Your Ref:
Our Ref : BR/81/11/
Please ask for:
Mrs A Stroud
01903 737500 Ext 37314
11th March 2011

Replace existing kitchen and study flat roofs and reconstruct conservatory with pitch roof and extension to form utility

22 Hillsboro Road Bognor Regis PO21 2DX

Replace existing kitchen and study flat roofs and reconstruct conservatory with pitch roof and extension to form utility
22 Hillsboro Road Bognor Regis

Title		
Elevations as Proposed + Typical Section

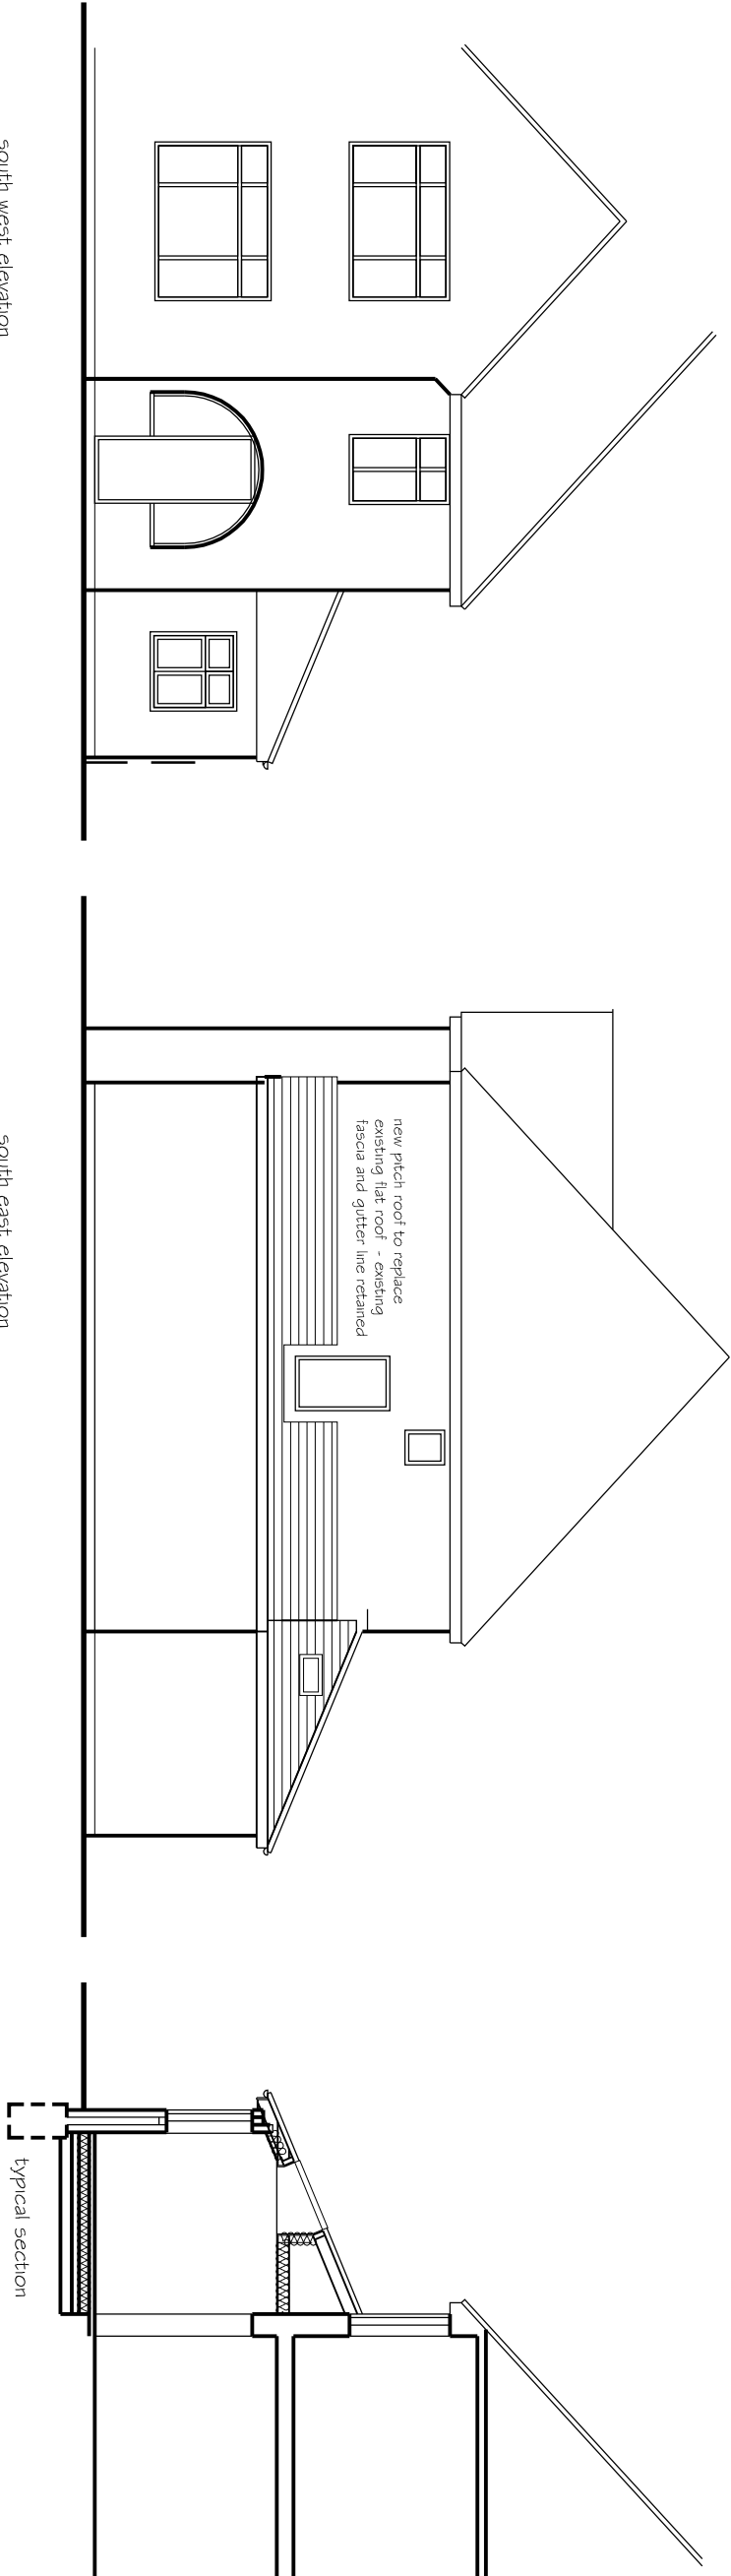
The proposed elevations are incorrectly labelled. Please amend and return accordingly.
